From: [REDACTED]
Sent: 26 February 2024 16:23
To: Planning
Subject: Planning Application Number 3/2024/0076 Land Off Hammond Drive, BB12 7RERead, BB12
Attachments: Photograph 1.jpg; Photograph 2.jpg; Photograph 3.jpg

[REDACTED] please accept this communication as confirmation of our objection to planning application number 3/2024/0076 – resubmission of planning application number 3/2023/0447 Land off Hammond Drive, Read, BB12 7RE.

PROPOSED ELEVATIONS

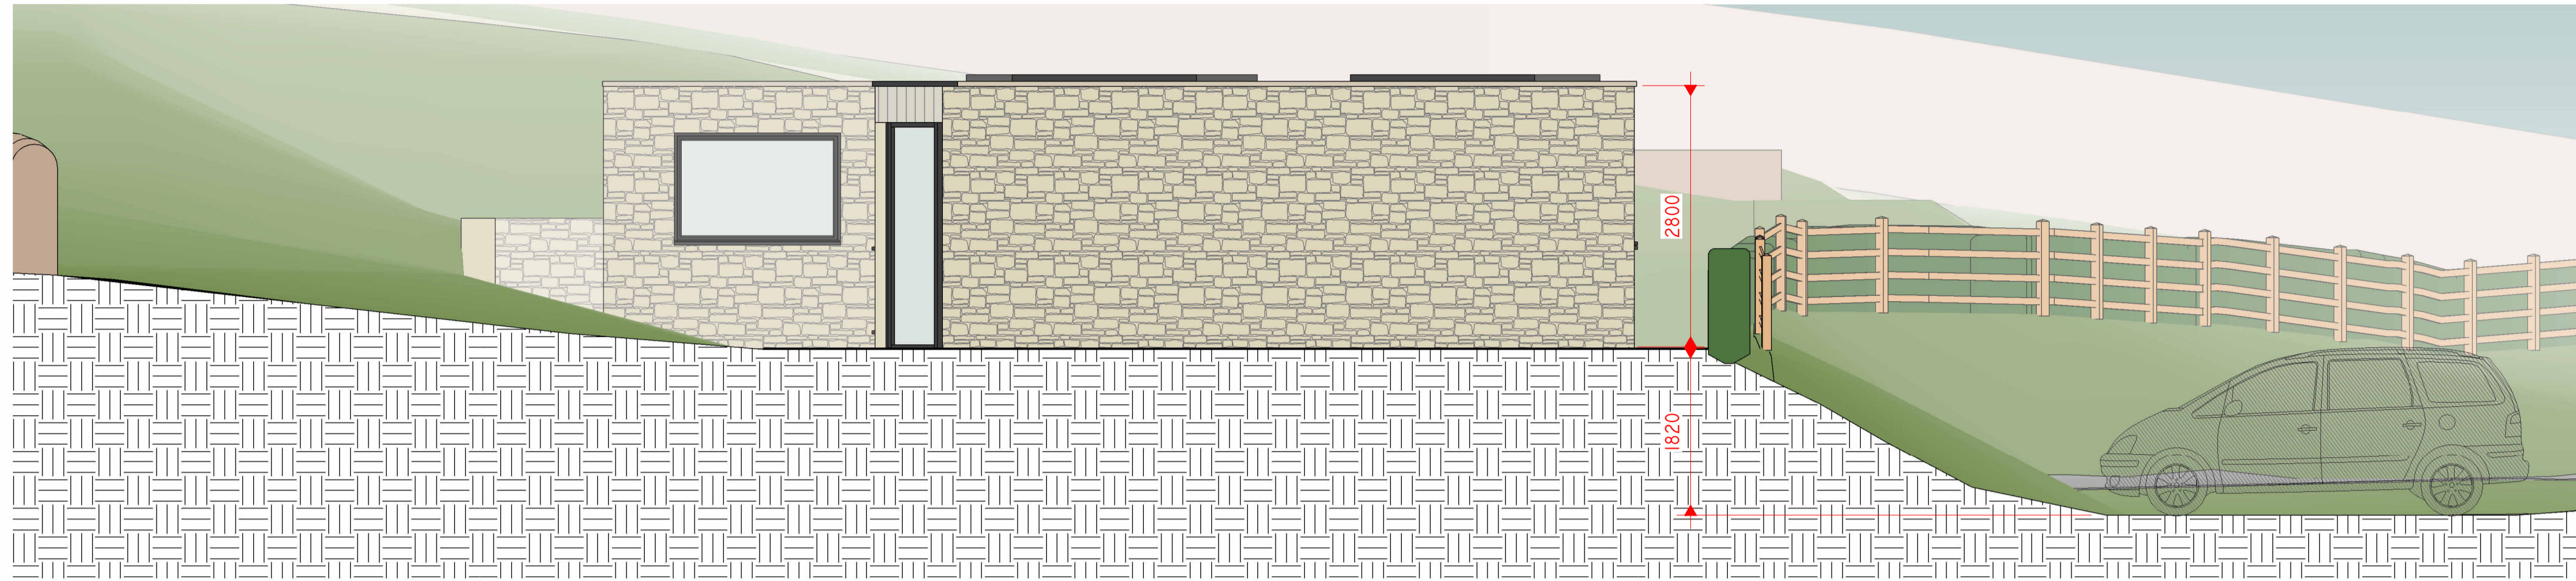
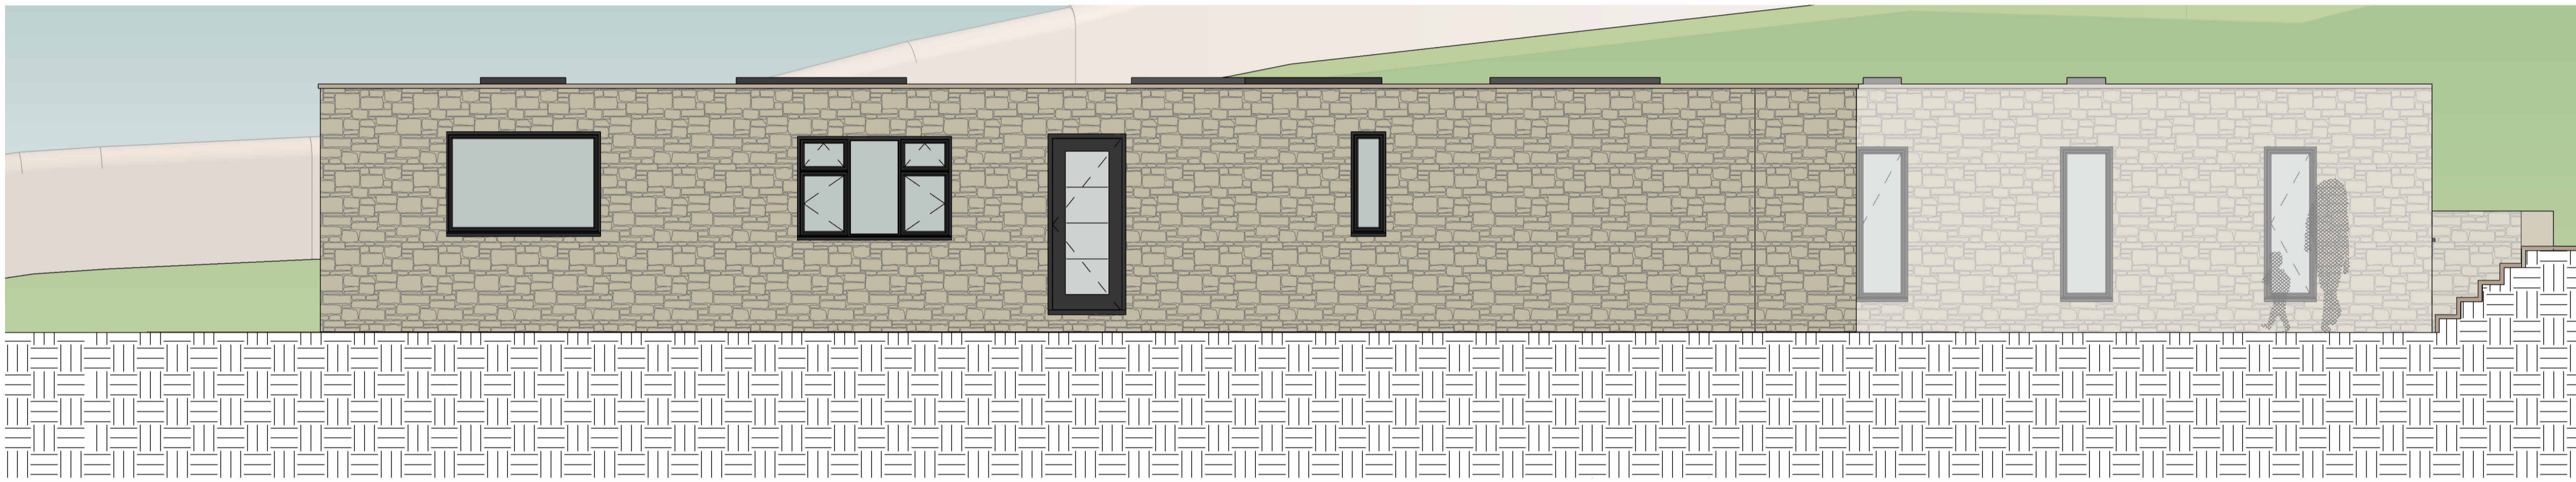
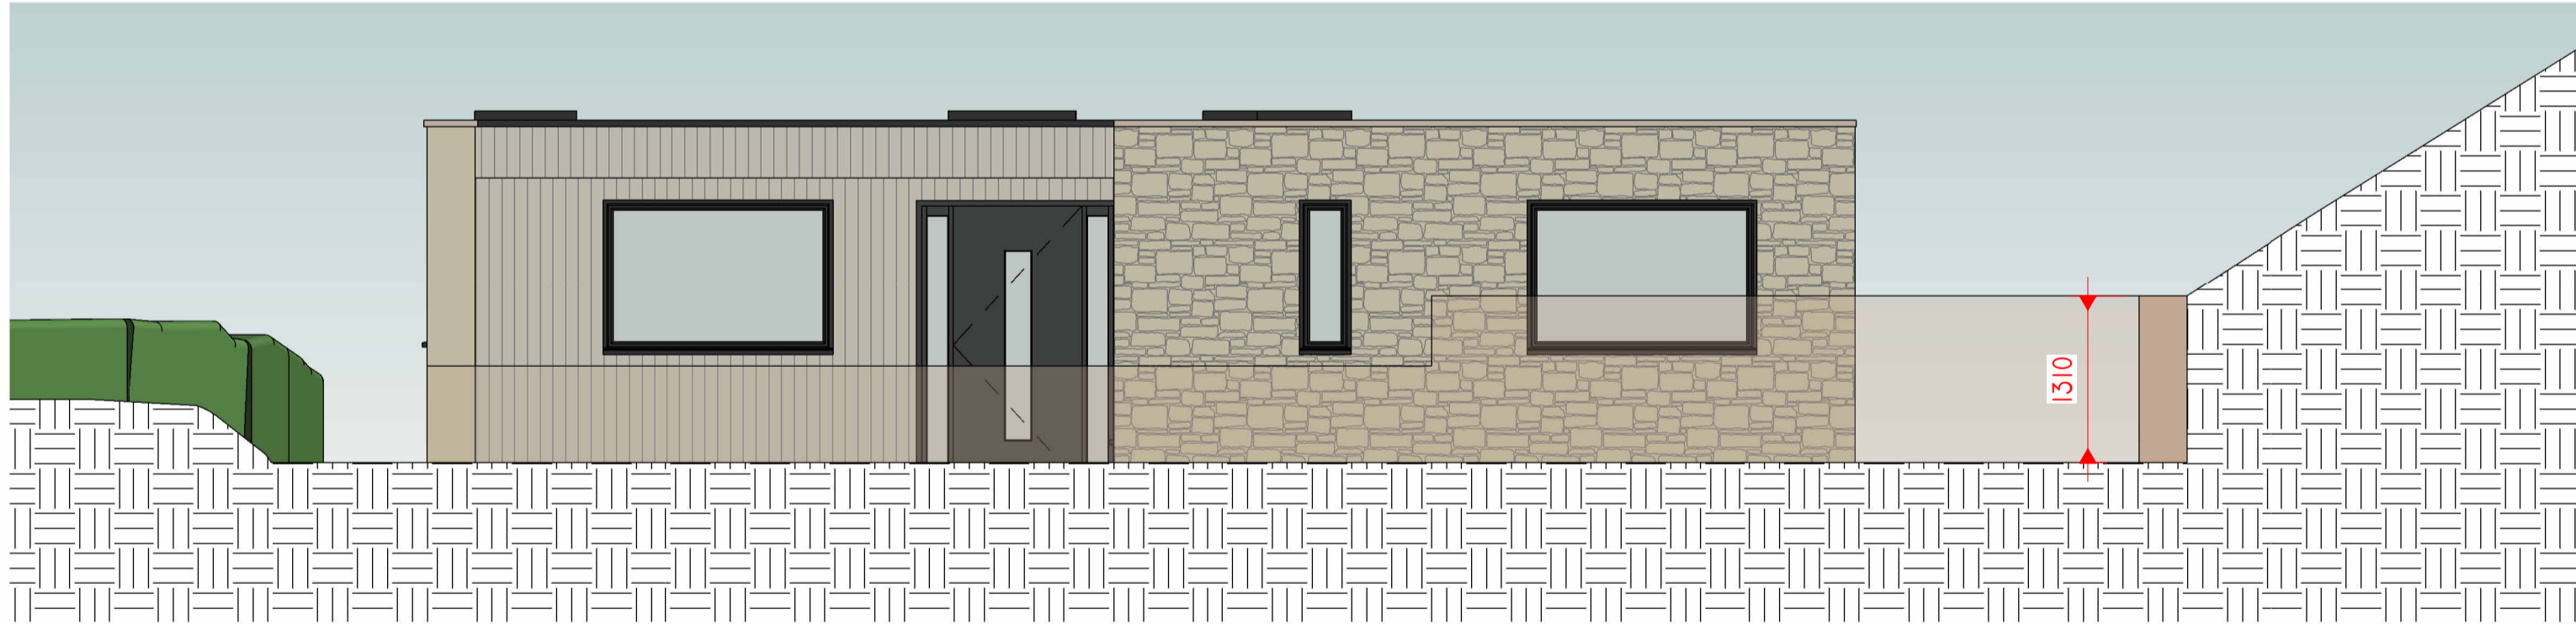
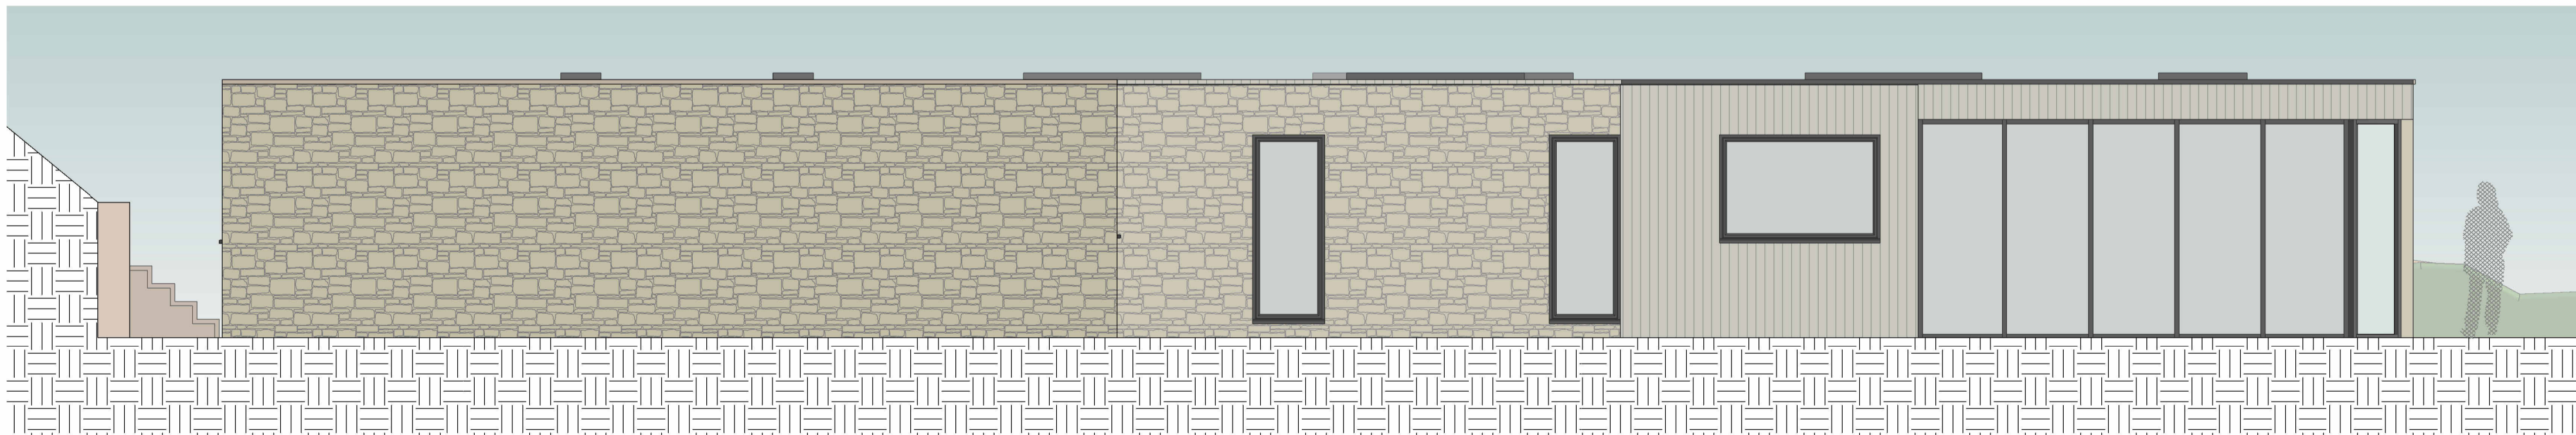
According to the site plan, the proposed new dwelling will be built at a ground level of 136.94 metres above sea level, with the roof topping out at 139.74 metres above sea level. For reference, please be aware that the height of the proposed new dwelling has increased from the original application according to the "Proposed Elevations" document.

SHEET:  
PROPOSED SECTIONS AND SITE ELEVATION

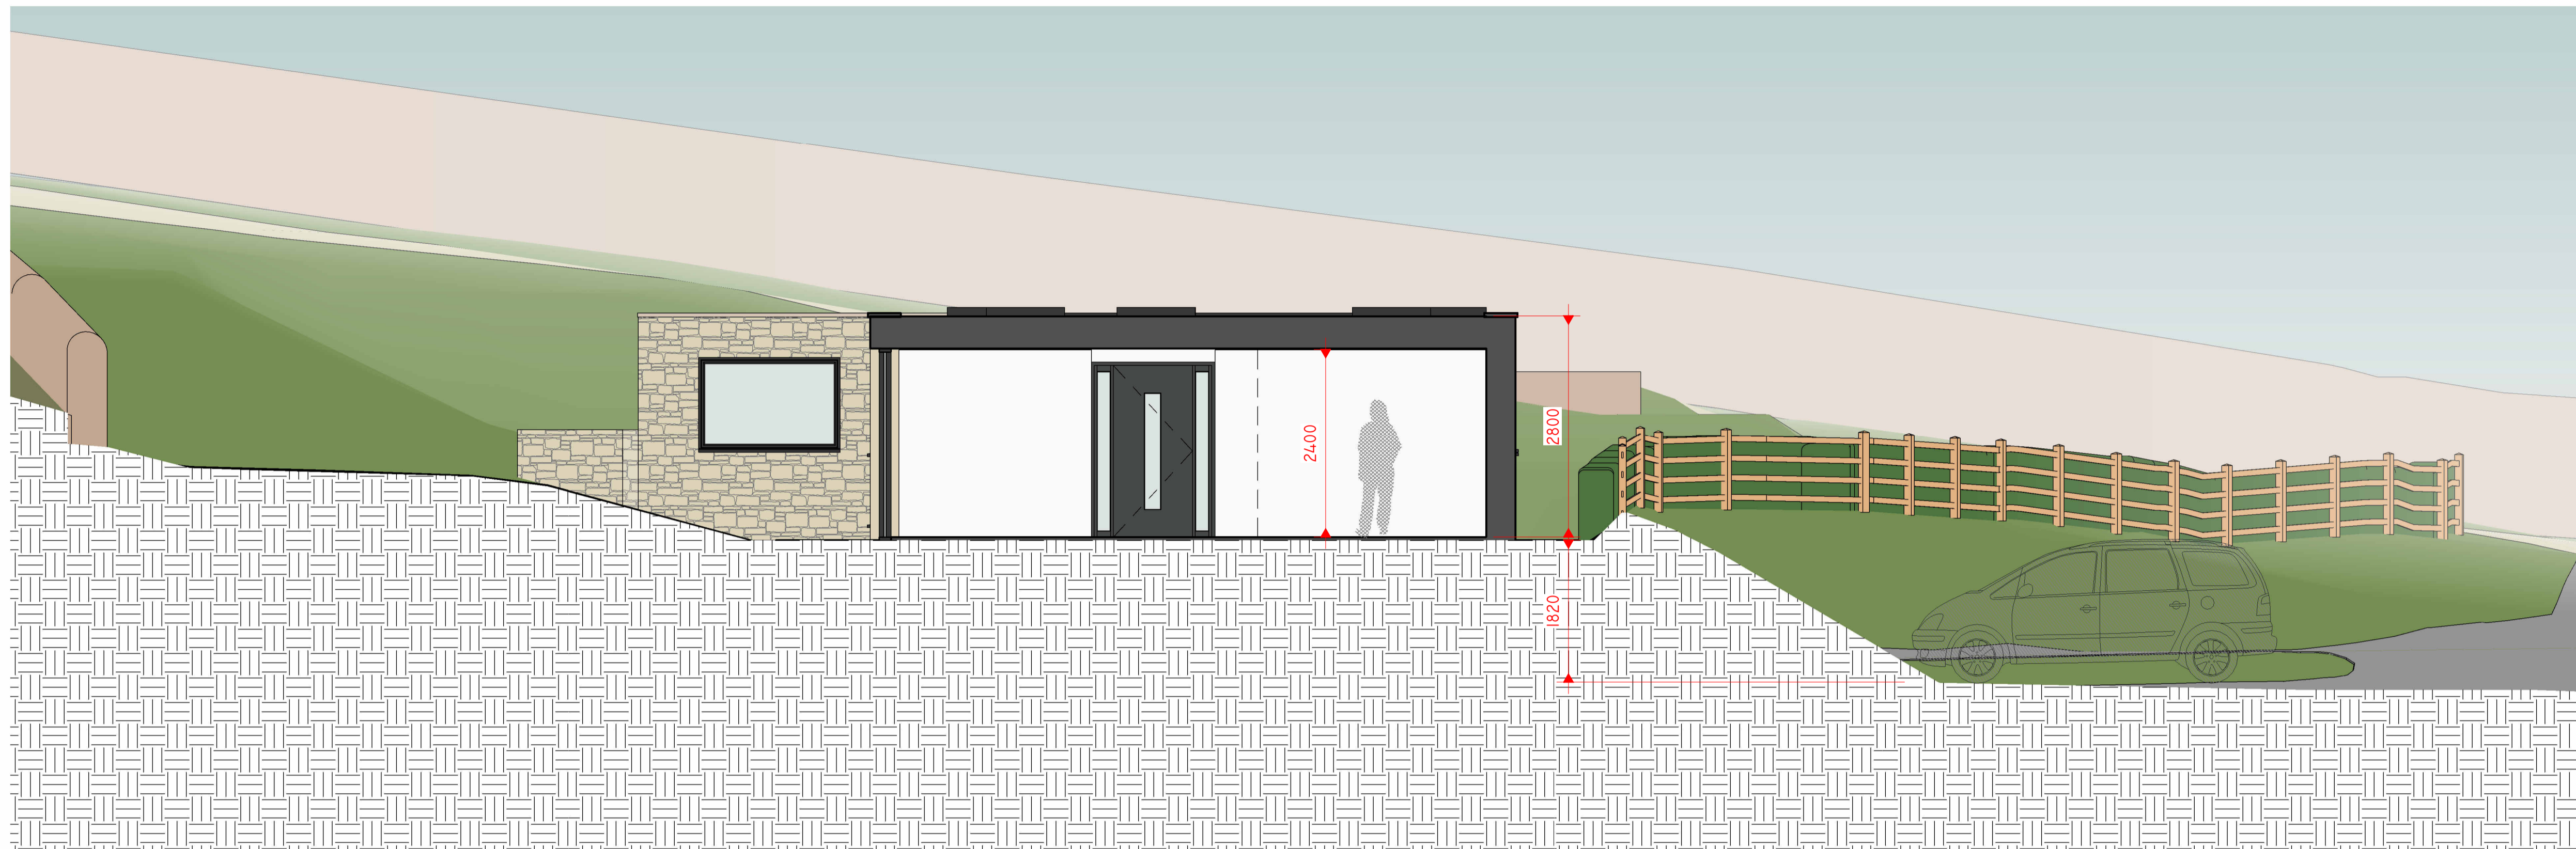
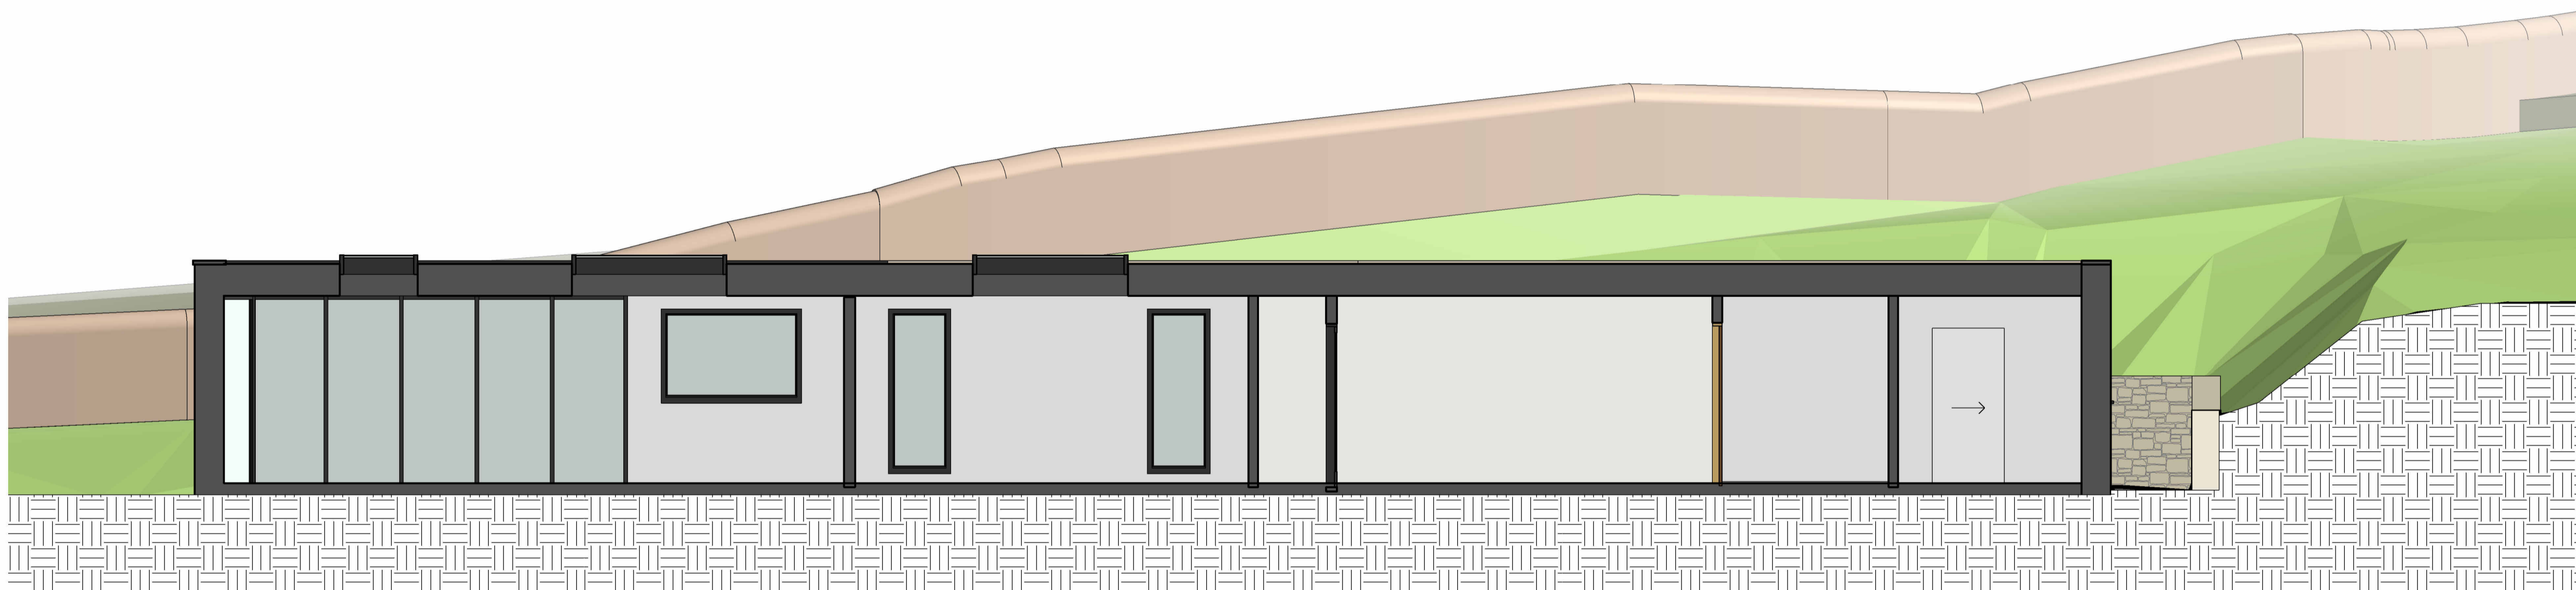
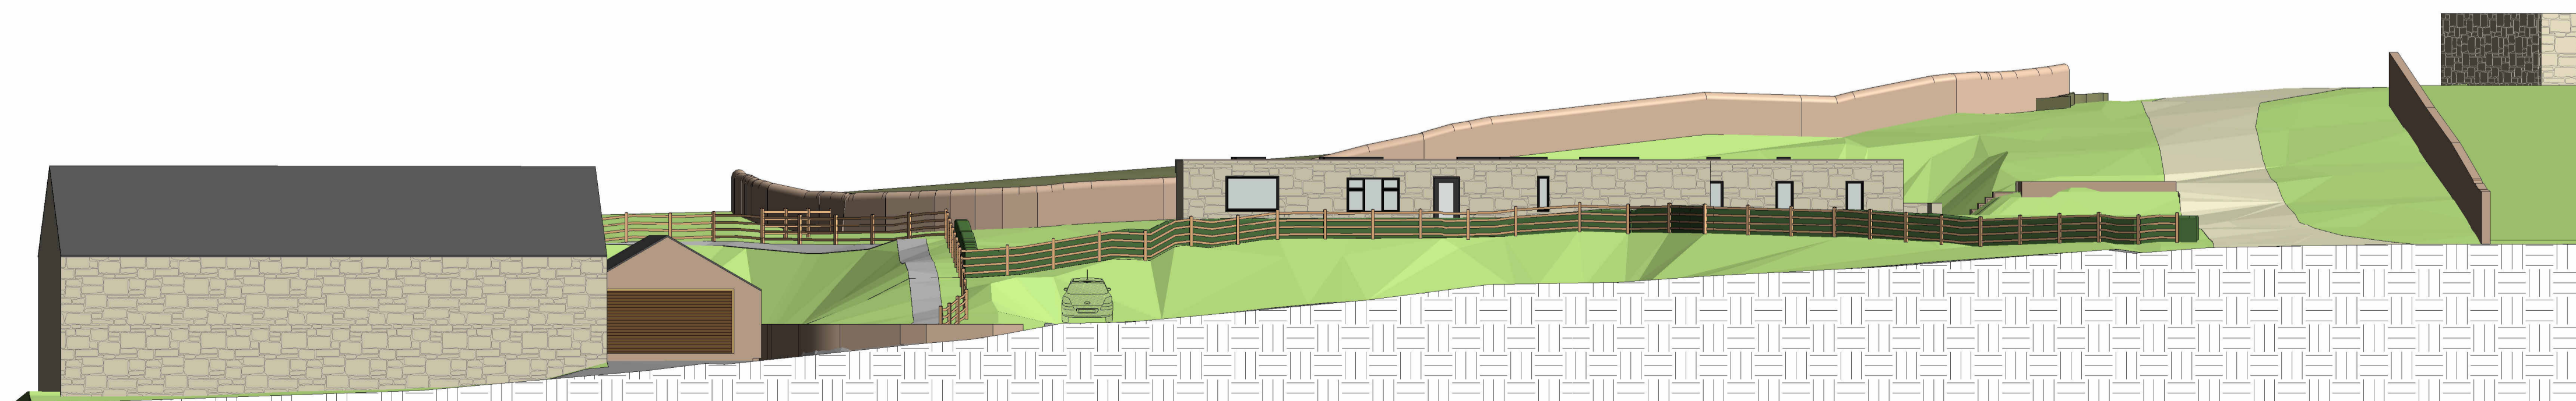
Potentially more poignantly [REDACTED] is the even greater discrepancy in the height between the proposed new dwelling [REDACTED] which would, if built, remove any privacy that currently exists. As previously stated, the proposed new dwelling will be at its highest 139.74 metres above sea level. The topographical survey shows [REDACTED] above sea level at threshold level (TL) a difference of 8+ metres. Furthermore, the topographical survey shows the eaves height (EH) [REDACTED] above sea level, which is still below the ground level height and almost 5 metres below the upper height of the proposed new dwelling. This height issue is clearly evidenced in the “Whole Site Elevation” drawing in the “Proposed Sections” document of the application.
